SEPA MITIGATED DETERMINATION OF NONSIGNIFICANCE

- Project:** Firkins Rezone (Z-08-01) and Preliminary Plat (P-08-02)
- Description:** A rezone from Ag-20 to Ag-3 together with a Preliminary Plat to subdivide approximately 15.03 acres of land into five (5) lots.
- Proponent:** Cam Sherwood
3323 Brickmill Road
Ellensburg, WA 98926
Representing Charles Firkins, landowner
- Location:** The project is located east of the City of Ellensburg, north of Vantage Highway, east of Wilson Creek Road on Game Farm Road, Ellensburg, WA 98926, and is located in a portion of Section 29, T18N, R19E, WM, in Kittitas County. Specific map numbers 18-19-29040-0008 and 18-19-29040-0009.
- Lead Agency:** Kittitas County Community Development Services

Date: April 21, 2008

FIRKINS PLAT
A PORTION OF SEC. 29, T. 18N, R. 19E, W.M.
KITITITAS COUNTY, WASHINGTON

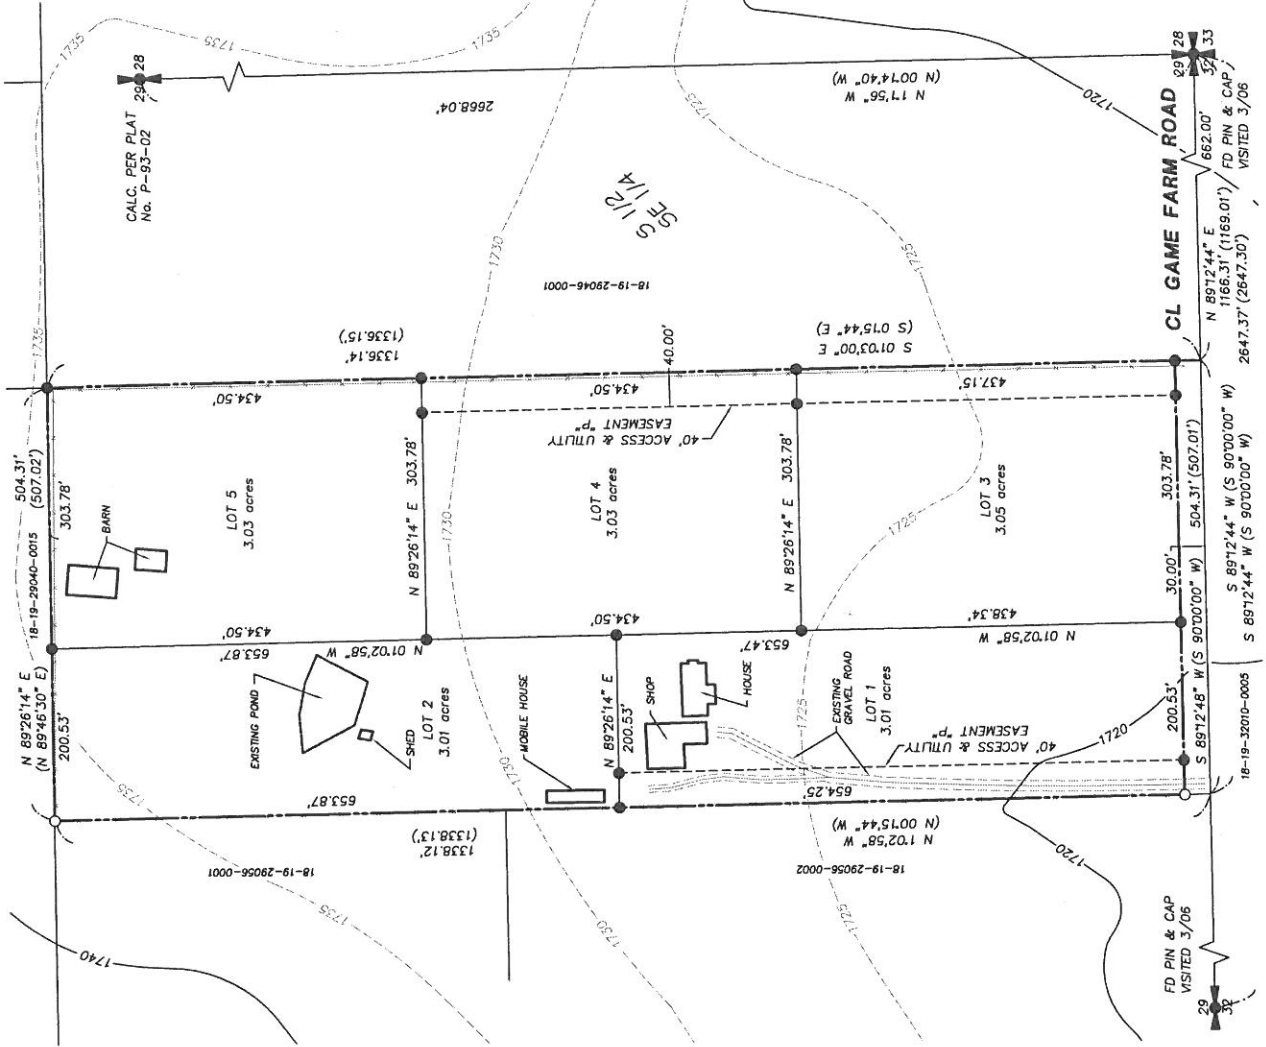
- A. The applicant shall be responsible for meeting or exceeding all conditions and requirements set forth by the Department of Public Works, as listed in the attached memorandum.
- B. There shall be only two access points off of Game Farm Road to serve the proposed subdivision. The two allowed accesses are those shown on the preliminary drawings. One access easement shall serve lots 3, 4 and 5 and end in a cul-de-sac. Lots 4 and 5 shall be accessed from a joint-use driveway beginning at said cul-de-sac.
- C. Lot 3 shall not be allowed direct access solely to and from Game Farm Road, but rather shall use the proposed easement as shown on the preliminary drawings.

- C. The existing well located on lot one (1) of the Firkins Plat (P-08-02) shall be used to serve only lot one (1) of the plat.
- D. The applicant shall develop a "Group B" water system to serve lots two (2), three (3), four (4), and five (5) of the Firkins Plat (P-08-02). The "Group B" water system will be designed by a licensed engineer and approved by Kittitas County Environmental Health.

- H. A plat note shall be added as follows:

Lot 2, Lot 3, Lot 4 and Lot 5 of the Firkins Plat (P-08-02) shall be served by a "Group B" water system, designed by a licensed engineer and approved by Kittitas County Environmental Health.

- I. A plat note shall be added as follows:

All wells for this plat shall be metered, including the individual well located on Lot 1, so as not to exceed the single groundwater withdrawal exemption of 5,000 gallons per day as set forth by the Department of Ecology. Water use data should be recorded by the property owner of the well on a monthly basis and Department of Ecology personnel shall have access at reasonable times to the records of water use.
